Re: Application by Highways England for an Order granting development consent for the proposed M20 Junction 10a – Written Representation

Appendix 1 - Kent County Council's written representations on Revision B of Volume 3.1 (October 2016) of the draft Development Consent Order for M20 Junction 10A

Report for – Ashford Borough Council M20 Junction 10A and A2070 Link Road Examiners Questions Draft

RIGHTS OF WAY AND ACCESS PLANS
REGULATION 5(2)(k) & 5(2)(o)
SHEET 3 OF 4

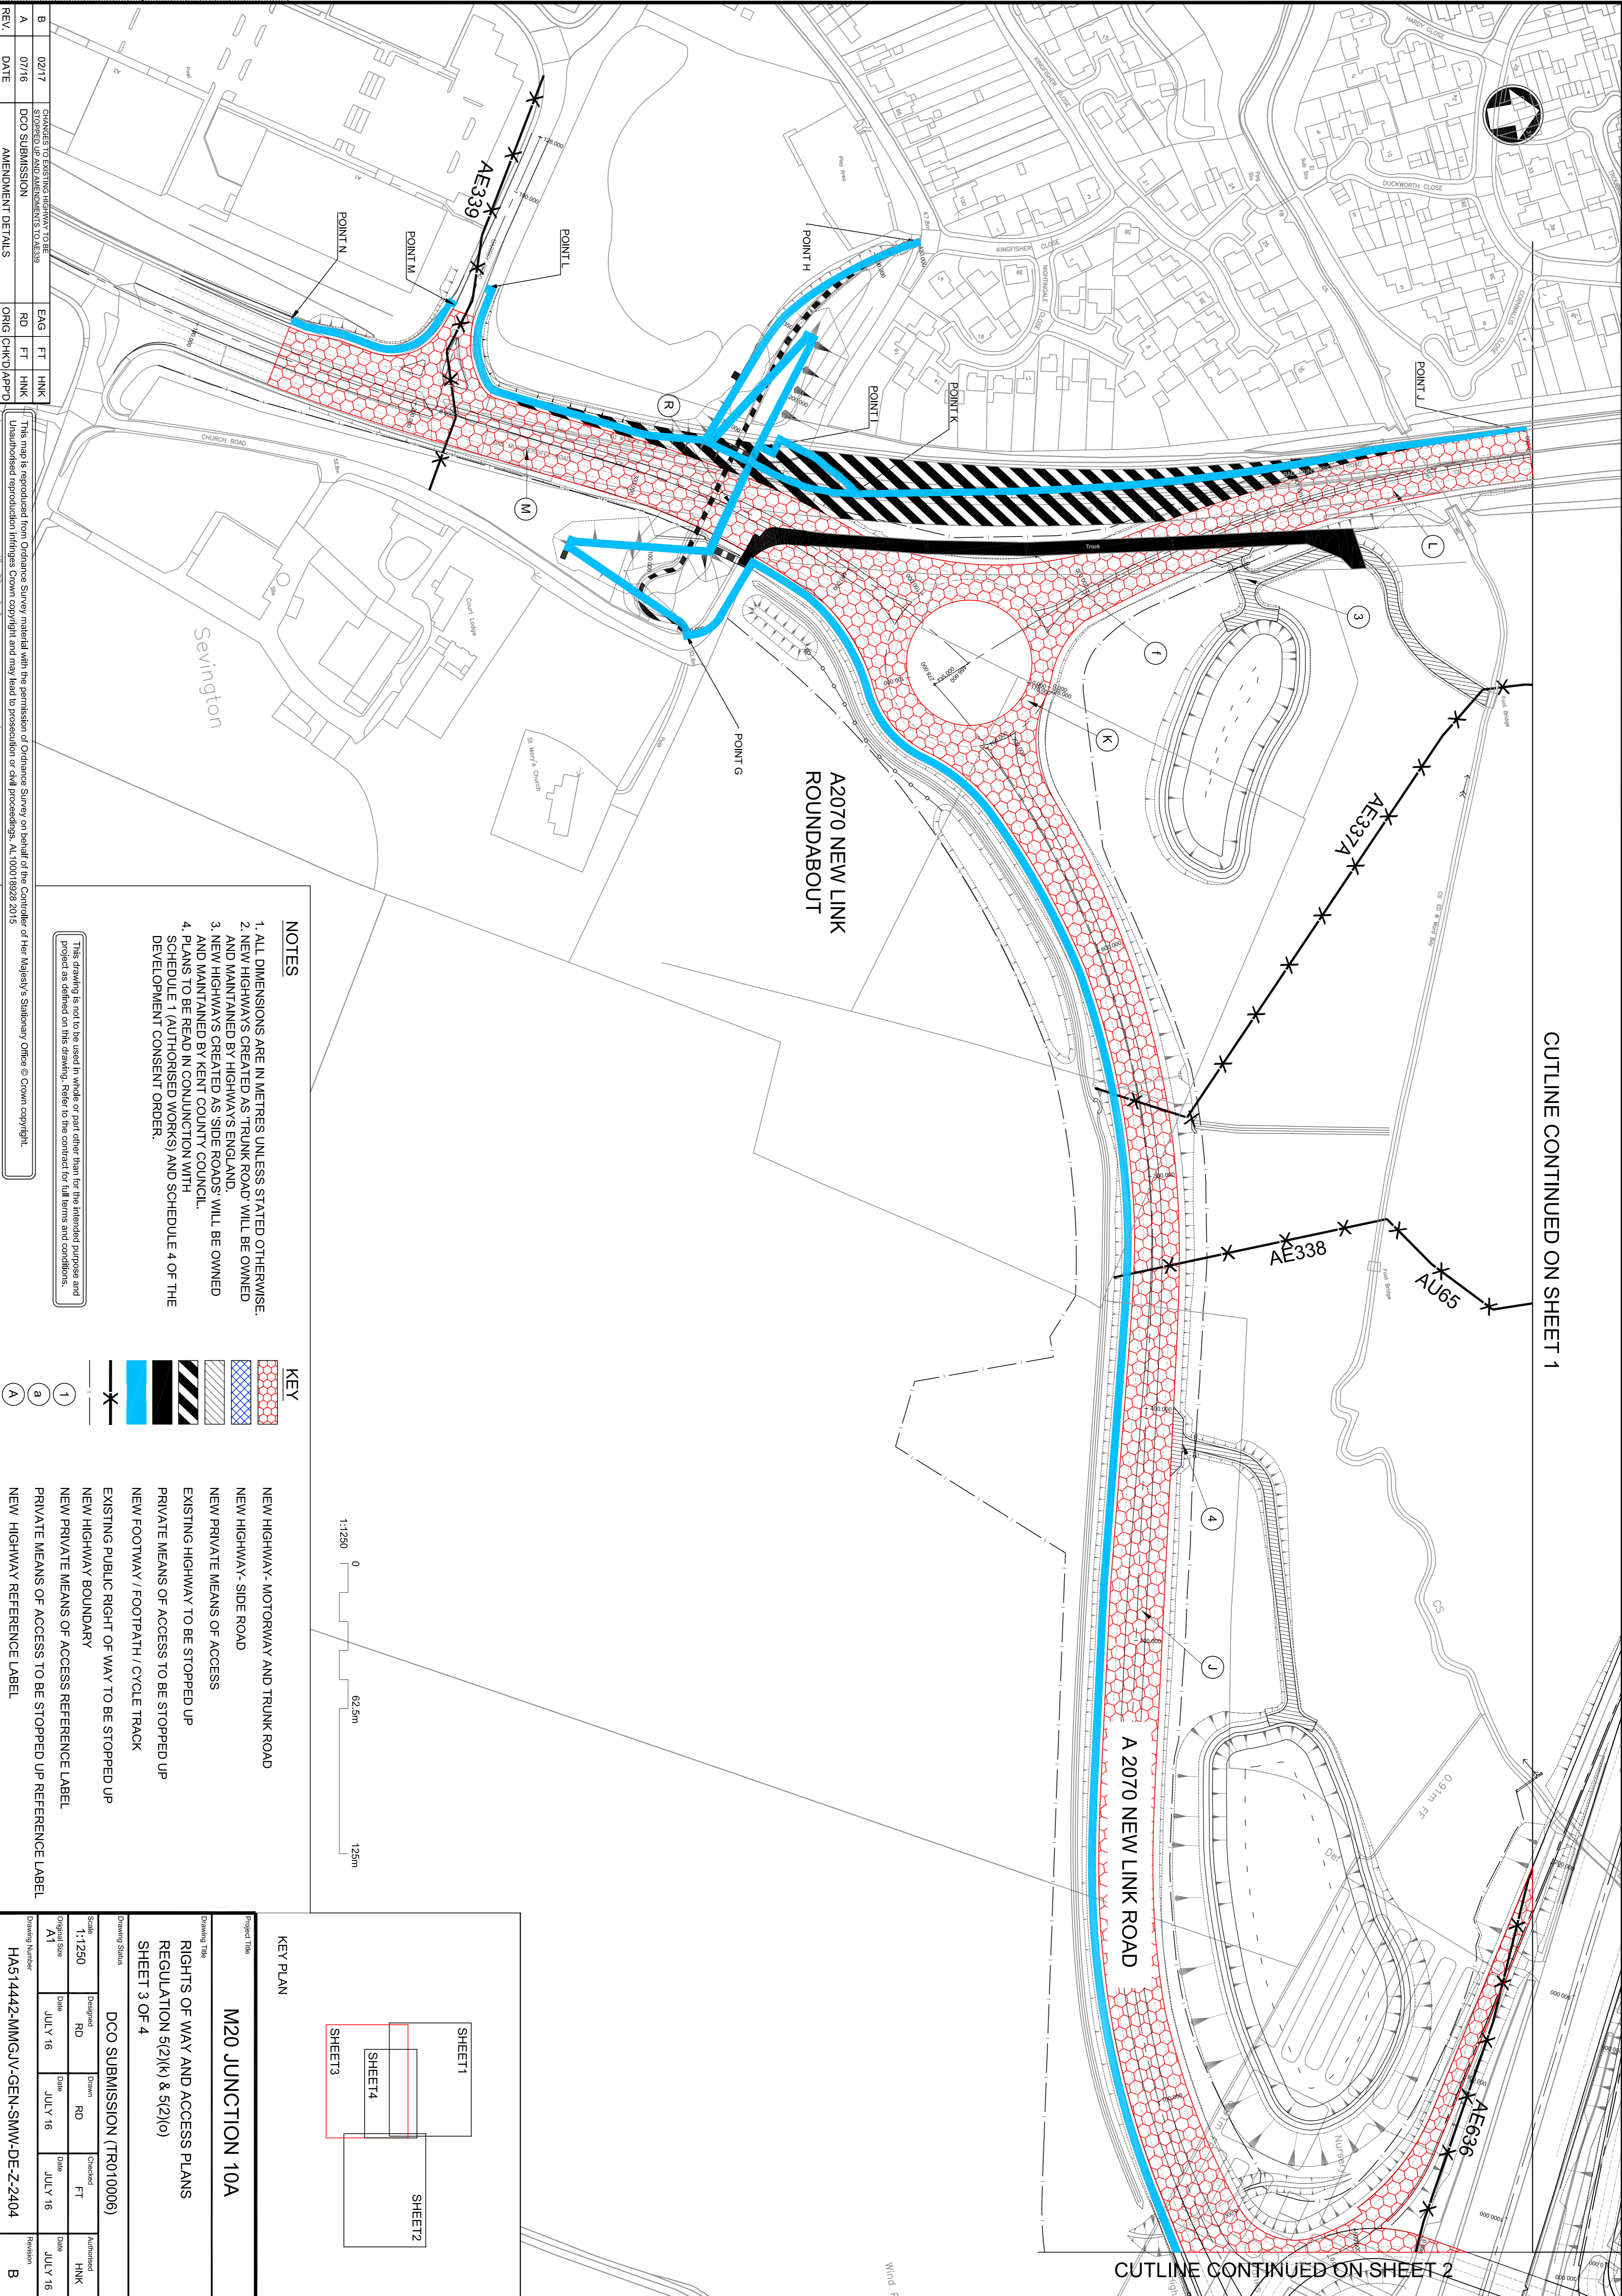
<p>The map and description for PRow AE339, Sevington is incorrect. The Public Footpath extends across the A2070 to Church Road Eats of the A2070. The description and corresponding plan should therefore reflect the following;</p> <p>Parish – Sevington Highway to be stopped up – Public Right of Way AE339 Extent of stopping up – From the Barrey Road/Church Road junction West of the A2070 to where it meets Church Road again, East of the A2070 a distance of 184 metres, shown on sheet 3 of the rights of way and access plans.</p> <p>A copy of the made DCO at the date of making the Order and posting of the Order, must be sent to KCC’s PRow & Access Service to allow changes to be made to the Definitive Map and Statement of Public Rights of Way</p> <p>For the avoidance of doubt path AE338 should also be annotated into the rights of way and access plan 3.</p>
26	One section of the identified land appears to be a track serving adjacent properties. More information is needed about whether there are any rights granted that affect this land.

Project Title		M20 JUNCTION 10A			
Drawing Title		RIGHTS OF WAY AND ACCESS PLANS			
Drawing Status		DCO SUBMISSION (TR010006)			
Scale		1:1250			
Original Size	Date	Designed	Drawn	Checked	Authorised
A1	JULY 16	RD	RD	FT	HNK
Drawing Number		HA514442-MMGLV-GEN-SMW-DE-Z-2403			
Revision		B

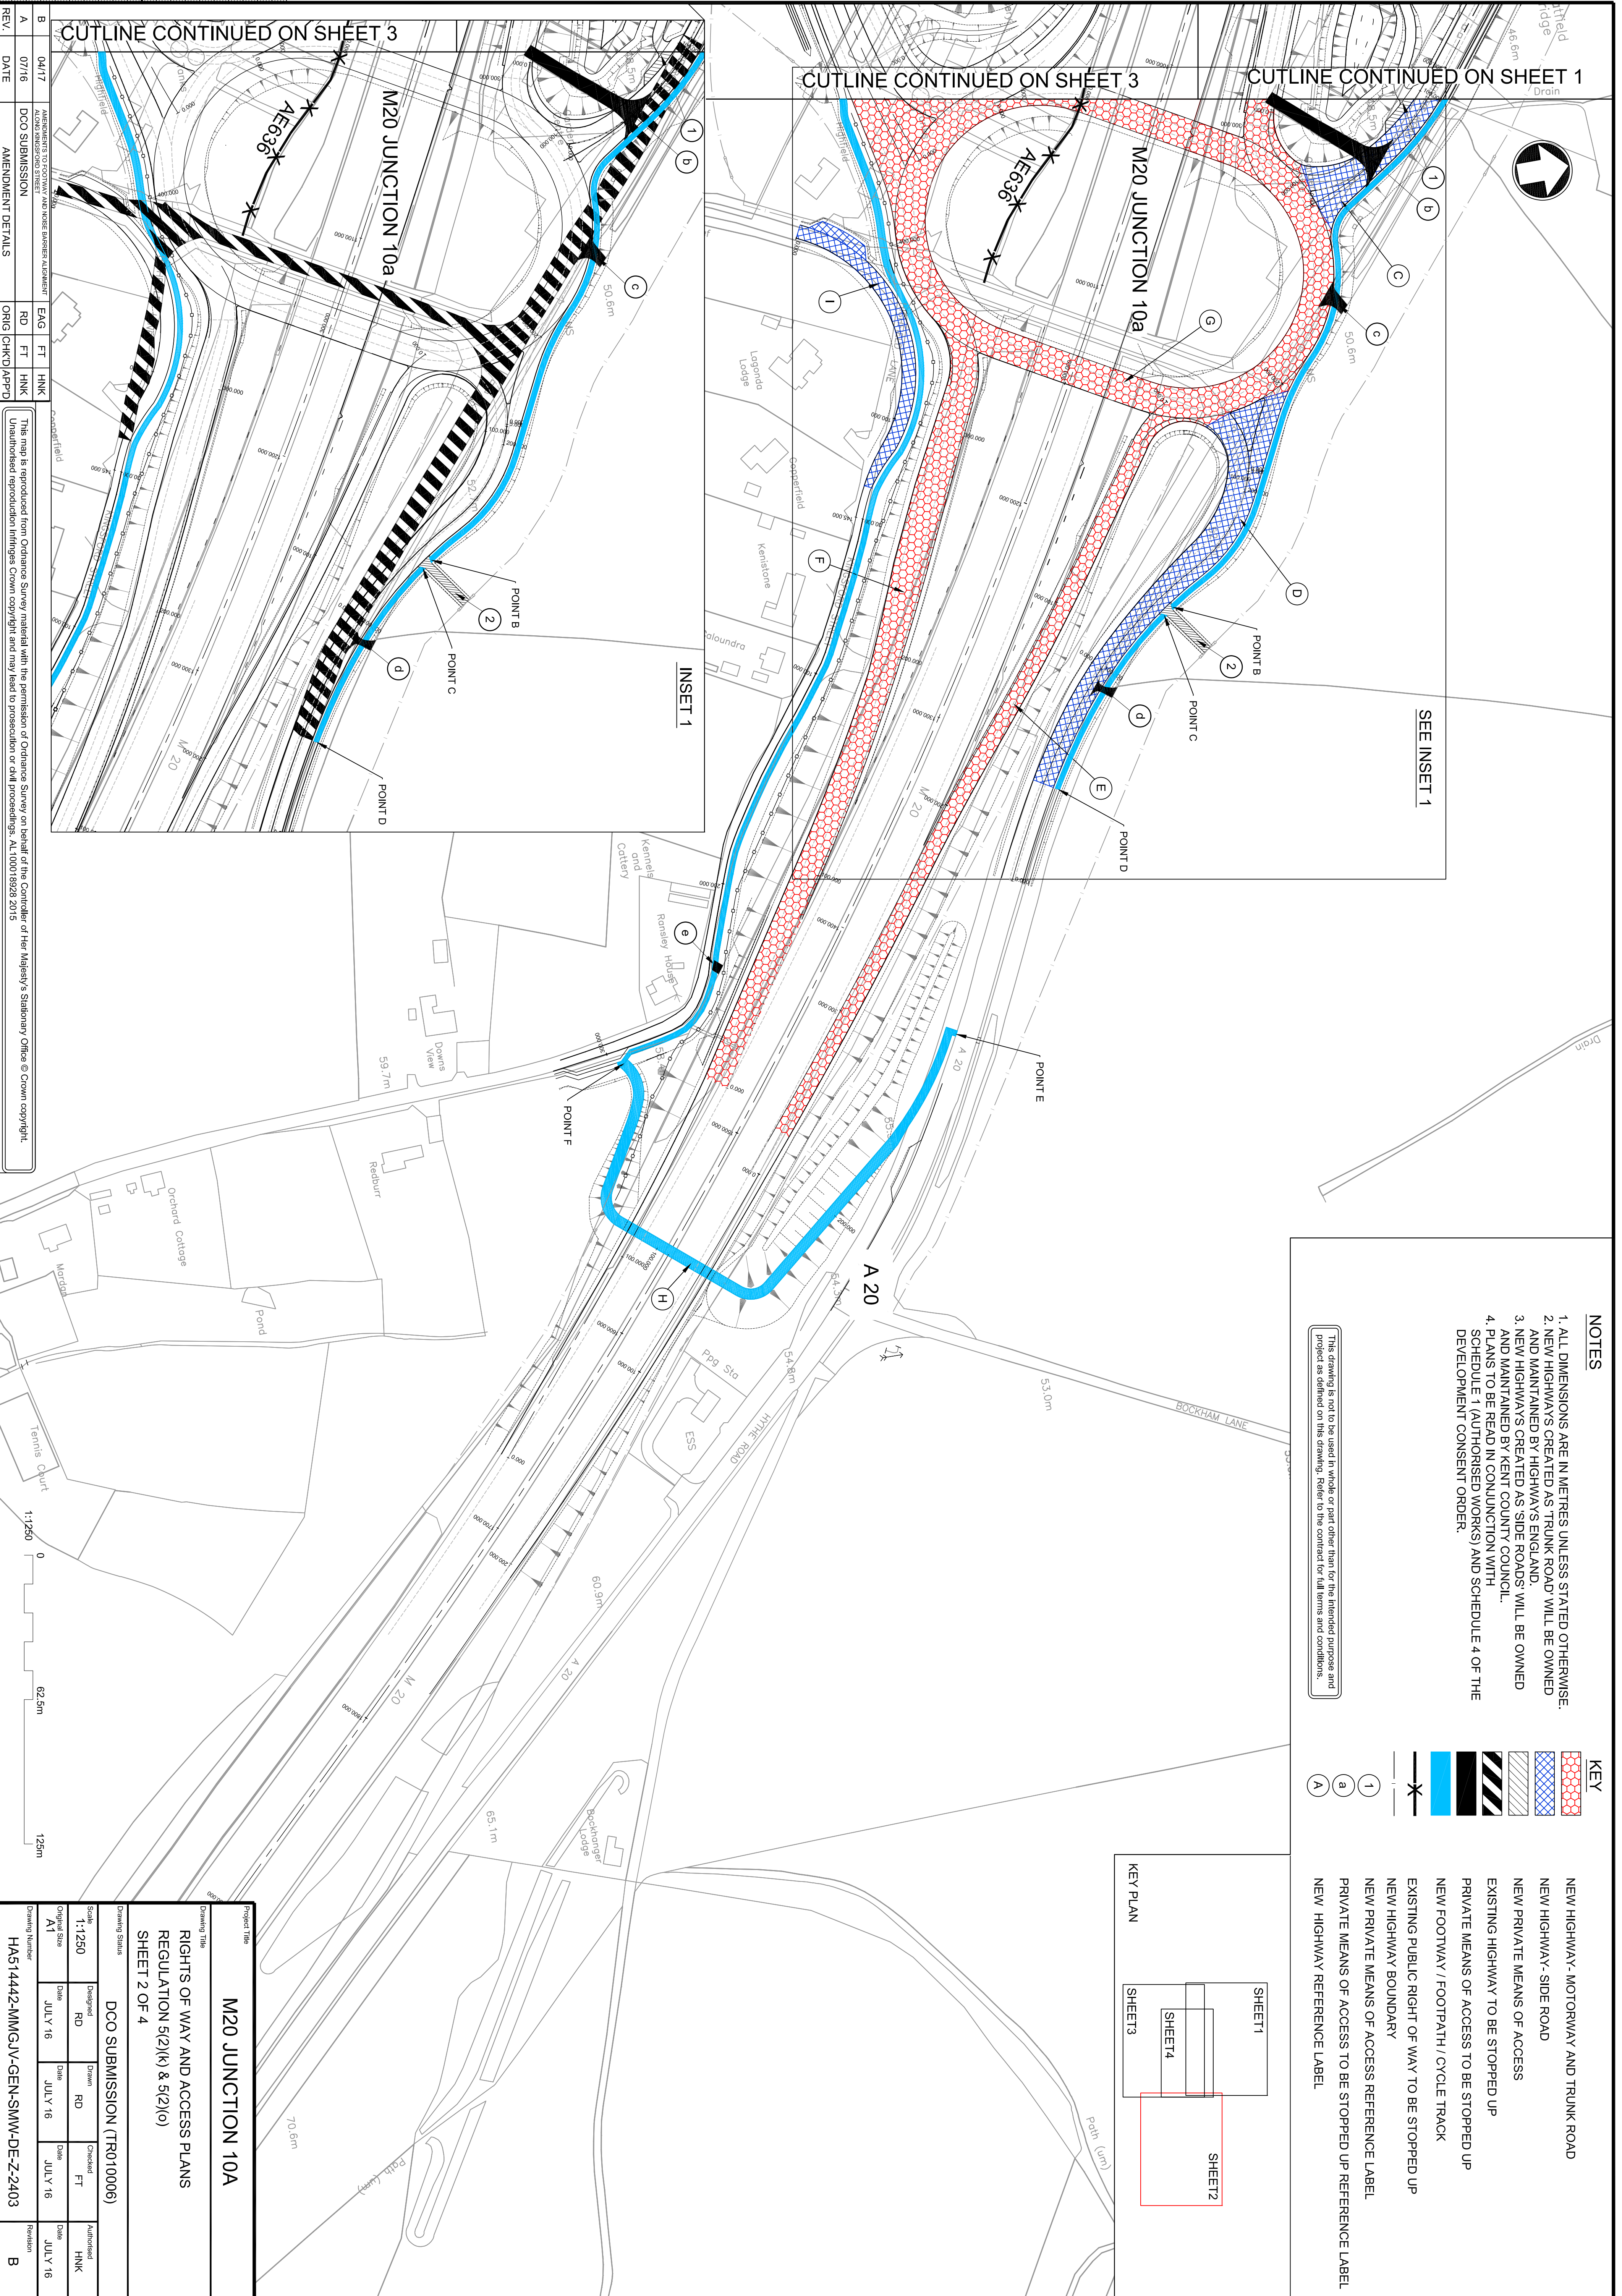
In relation to PRow – south side, KCC would expect drawings to show gaps in any drainage ditches/lagoons, to show that connections from the retained PRow are physically possible. This is a simple but necessary change, which KCC is not content has yet been adequately addressed.
